City of Albuquerque Stormwater Construction Site Inspection Report

General Information					
ESC File No.	K09E048D		Project Name:	Caliber Collision	
NPDES Id. No.	NMR100607 & 08		Location:	250 98th St NW	
9/19/2024	Owner		Contractor		
Operator	Cross Development CC Albuquerque, LLC		Madewell Construction		
Contact name & title	Joe Dell		Paul Hubbard		
e-mail	Joe@crossdevelopment.net		paul@madewell-construction.com		
Contact Phone #	214-762-1824		937-798-1475		
COA Inspector	Doug Hughes		Time	10AM	
Construction Phase:	grading				
Type of Inspection:	Regular	Storm Event	Post Storm Event >0.25"	311/Complaint	Follow Up
Weather at time of inspection?			Temperature: ~ 69		
Estimated date of last storm 0.25" or greater			8/27/2024

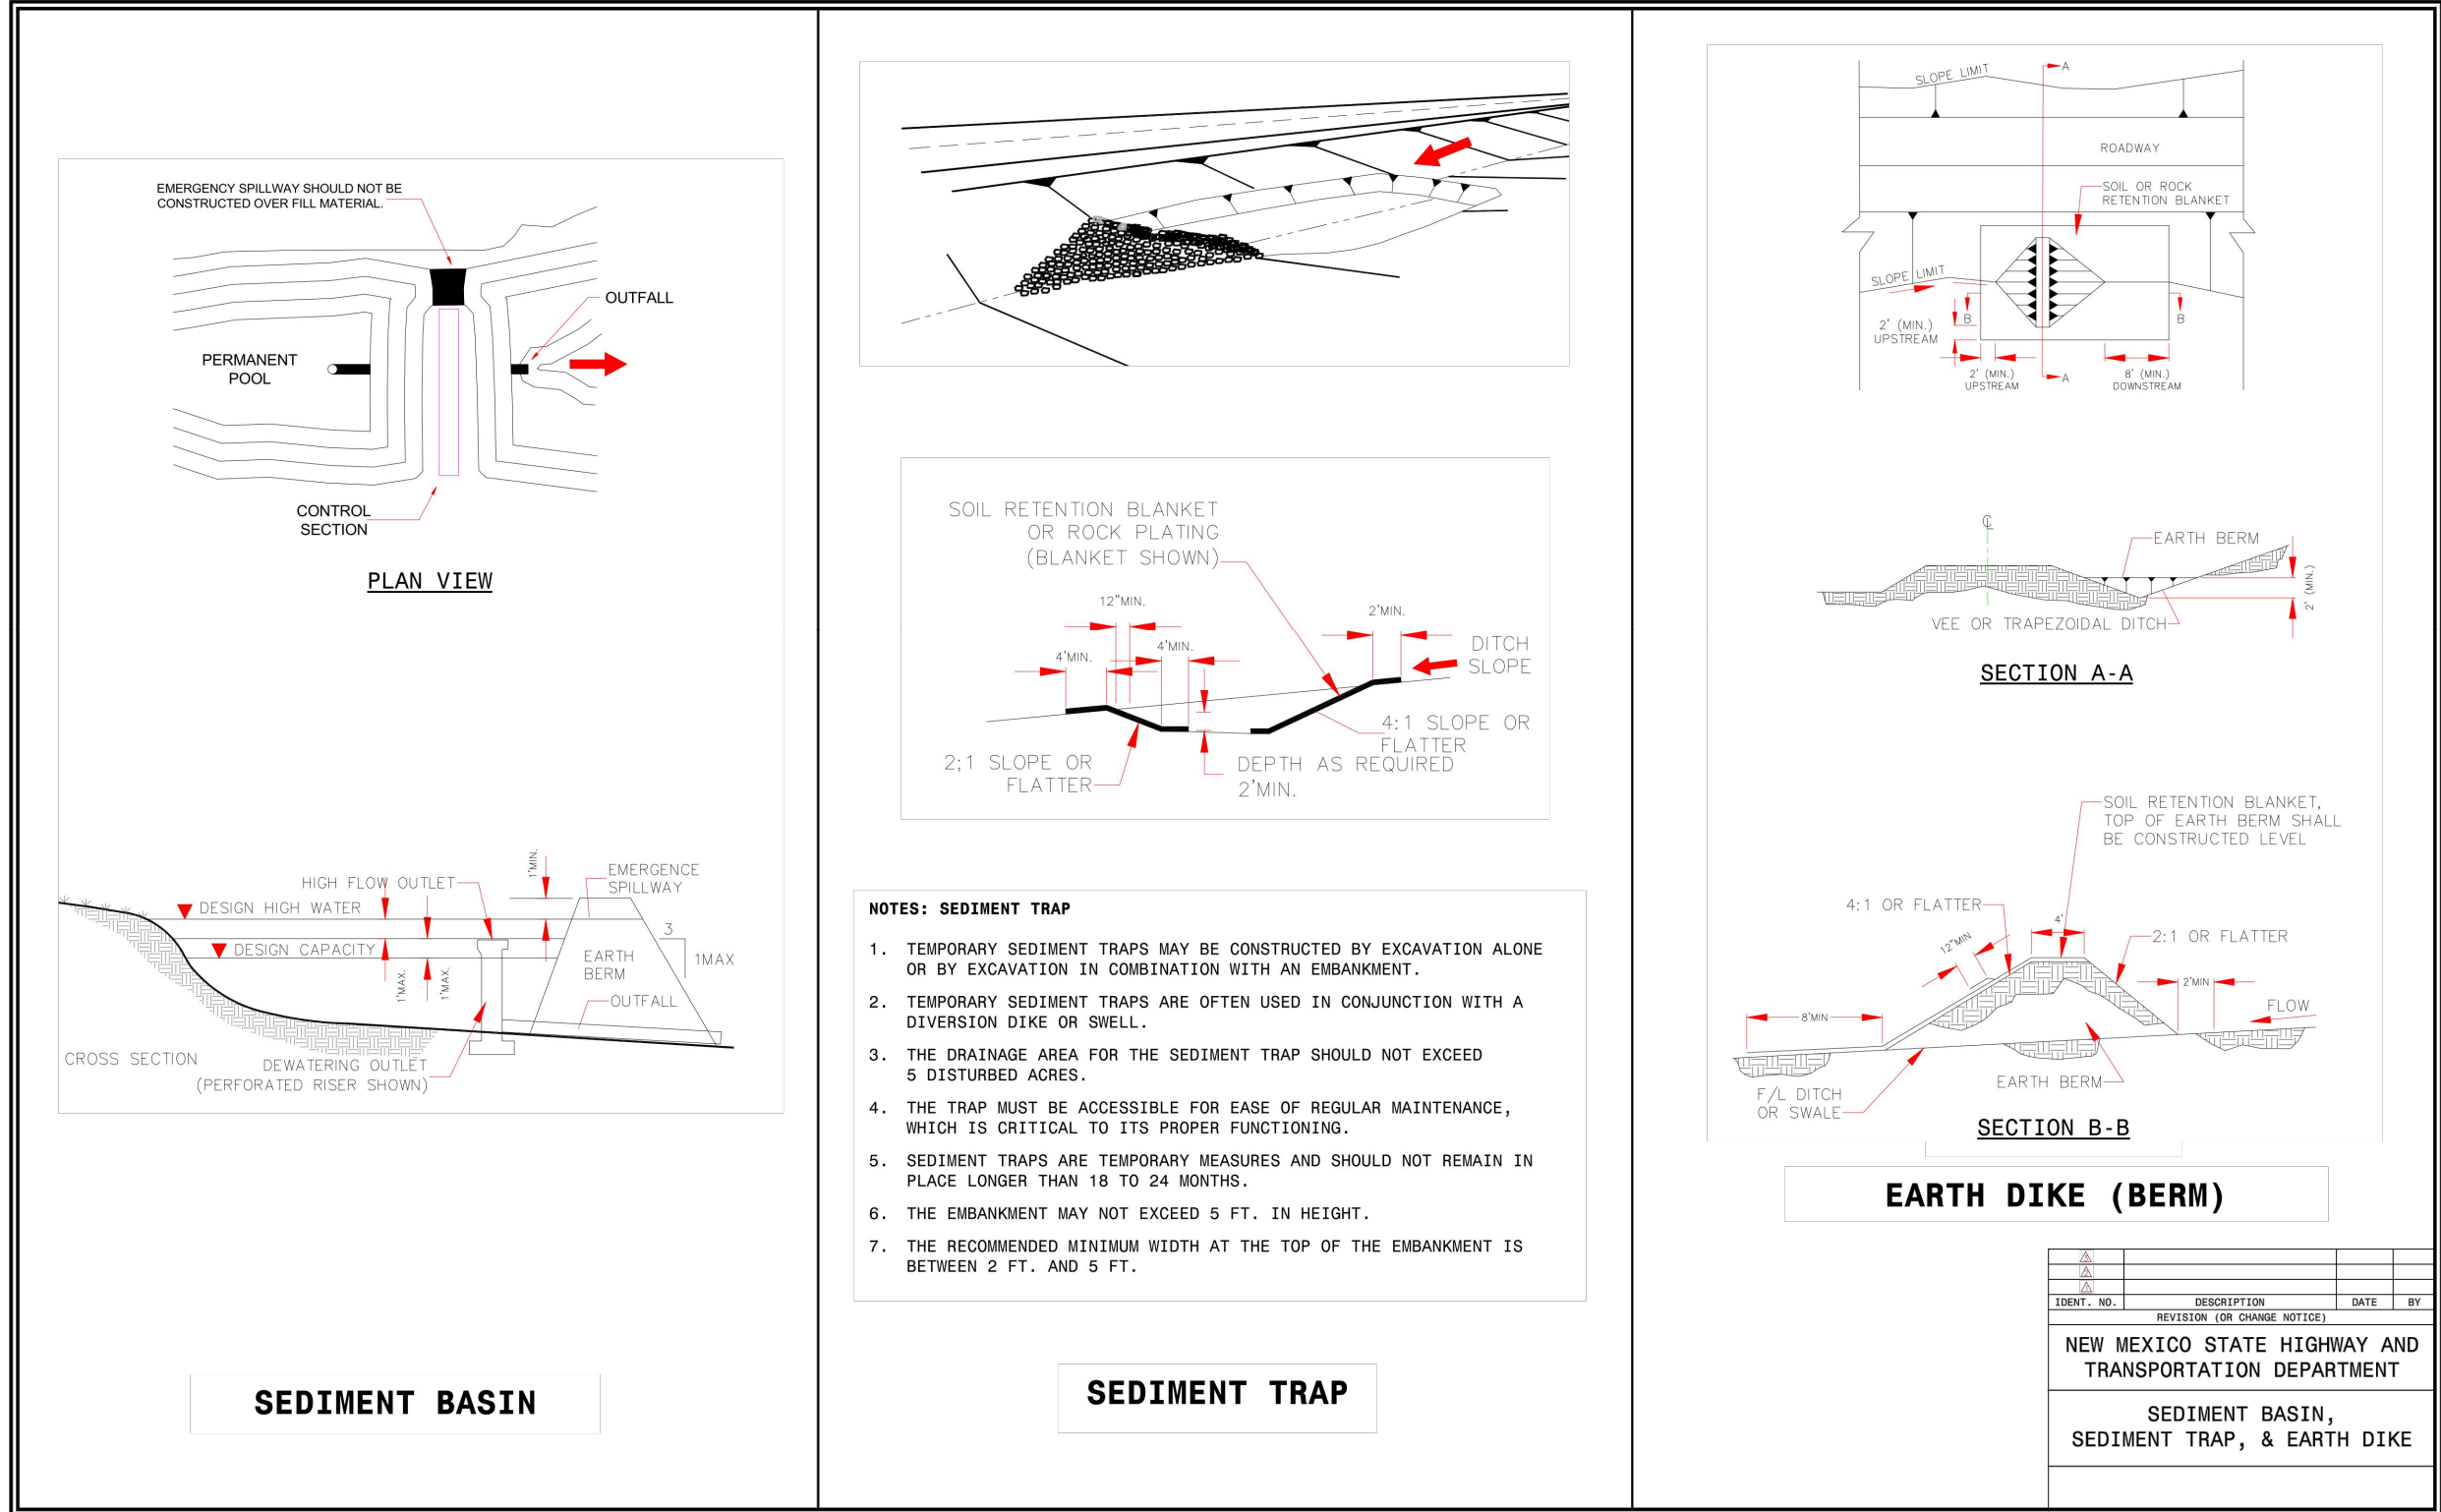
Item Number	Deficiency/ Corrective Action				
2	Stabilization —All perennial vegetation was removed from this site as part of the subdivision development that started in late 2022, and it was not replaced, so this site was still under permit coverage when this project started. The south half-acre is inactive and not properly stabilized in violation of CGP 2.2.14. Weeds in that area are in violation of the Weed, Litter, and Snow Removal Ordinance (§ 9-8-1). Required Mitigation: Stabilize the inactive disturbed areas and “large bare areas” per CGP 2.2.14.c.i. Implement and maintain stabilization measures in areas that remain inactive for 14 days or more. Measures must be initiated within 14 days and completed no later than 14 days per CGP 2.2.14.				
2	Sediment —Dirt was in the street at the construction exit and not removed within 24 hours in violation of CGP 2.2.4.d. Dirt ramps are prohibited. Required mitigation: Remove sediment deposited in the streets by the end of the same business day. Remove the sediment by sweeping, shoveling, or vacuuming these surfaces or using other similarly effective means of sediment removal. You are prohibited from hosing or sweeping sediment downstream per CGP 2.2.4.d.

3	BMPs - The Silt Fence was missing around the south half acre of the site in violation of CGP 2.1. Earthwork had blocked the temporary diversion swale on the east side of the property, potentially creating a new erosive discharge point into the neighbor's property to the east in violation of CGP 2.2.11. Required mitigation: If at any time you find that a stormwater control needs routine Maintenance, you must immediately initiate the needed maintenance work and complete such work by the close of the next business day. When the problem requires a new or replacement control or significant repair, install the new or modified control and make it operational or complete the repair by no later than seven (7) calendar days from the time of discovery per CGP 5.2.1.				
4	SWPPP - The SWPPP wasn't up-to-date in violation of CGP 7.1, and the self-inspection reports were missing in violations of City Ordinance § 14-5-2-11(C)(1) and CGP 4.7.3. The operator's SWPPP certification was missing in violation of CGP 7.2.10 The 2022 CGP wasn't available in violation of Violation of CGP 7.2.11.c. The operators deligated signatory authority to E2RC which isnt allowed because E2RC is a third Party per Required Mitigation: The SWPPP, including the SWPPP Map, Self Inspection Reports, and Corrective Action Reports, must be kept up-to-date per CGP 7.1 and available on-site per CGP 4.7.3, 5.4.3 and 7.3. If an on-site location is unavailable to keep the SWPPP when no personnel are present, notice of the plan’s location must be posted near the main entrance of your construction site CGP 7.3.

2.1	Discharge off site? (Y/N)	yes			
4	Self Inspection Reports	requested	Latest report Date:	missing	
Notes:					
Washout container was missing.
